Date: 17 January 2025
Our ref: 497689
Your ref: **EN010128**

NSIP Reference: EN010128

**The Examining Authority's first written questions and requests for information (ExQ1).
Examining Authority's submission deadline: 17 January 2025**

Annex 1: Natural England’s response to the Examining Authority’s (ExA’s) first written questions reference ExQ1

Table indicating Lux Level

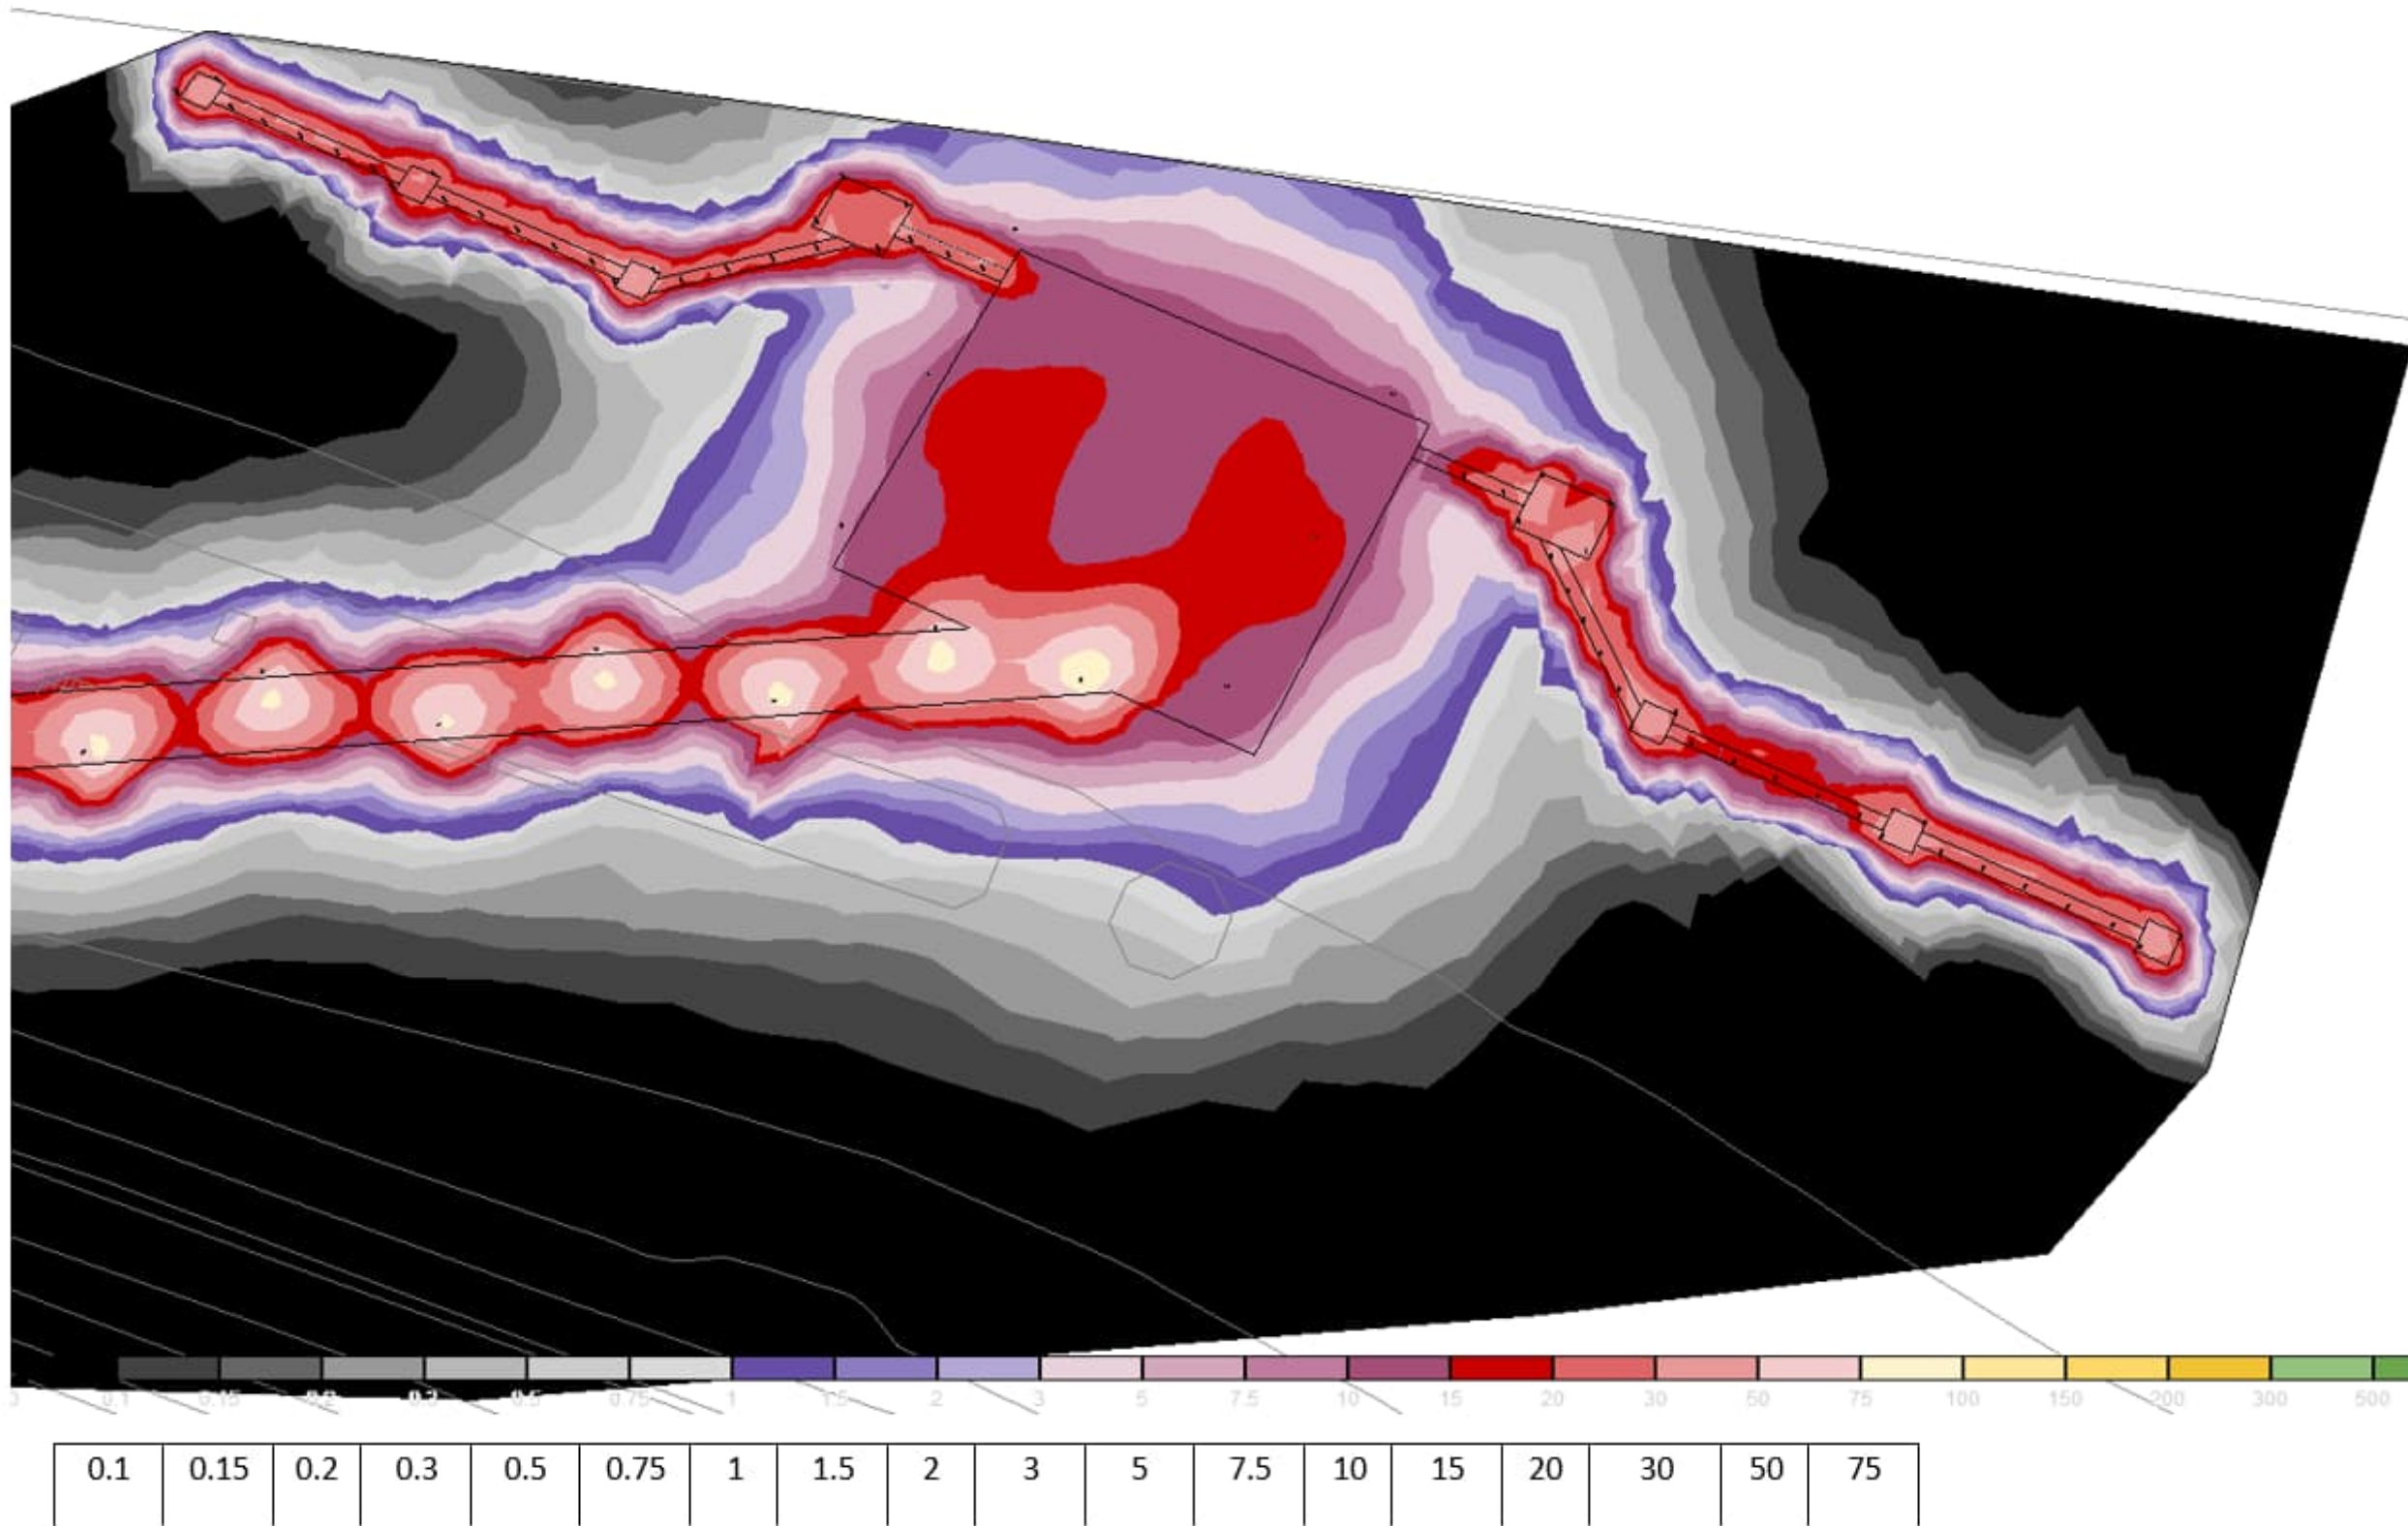
Q 1.3.1.5	The Applicant, NE and EA	<p><i>Would the lighting strategy required by Requirement (R) 11 in the dDCO be capable of mitigating effects of lighting on water voles? If so, please provide a full and detailed justification and if not, what alternative arrangements are proposed?</i></p> <p>The effects of lighting were not discussed as an impact to water voles within the Method Statement that Natural England reviewed. The lighting strategy [APP-123] does not specifically address potential impacts to water voles, or the mitigation of any impacts. Natural England has advised the Applicant that this section should be revised within the re-submitted version in order to ensure all the impacts of the proposed development are considered.</p>

ExQ1	Question to:	Question and Answer:
		<p>In principle, yes. We advise that we believe the wording of R 11 [REP1-002] as proposed, should be capable of ensuring any impacts to water voles are avoided or mitigated. The effectiveness of the requirement relies upon the detail and content of the lighting strategy [APP-123]. As discussed above, the lighting strategy [APP-123] does not currently specifically address potential impacts to water voles, or the mitigation of any impacts.</p> <p>Natural England would be pleased to be consulted on updates to the lighting strategy.</p>
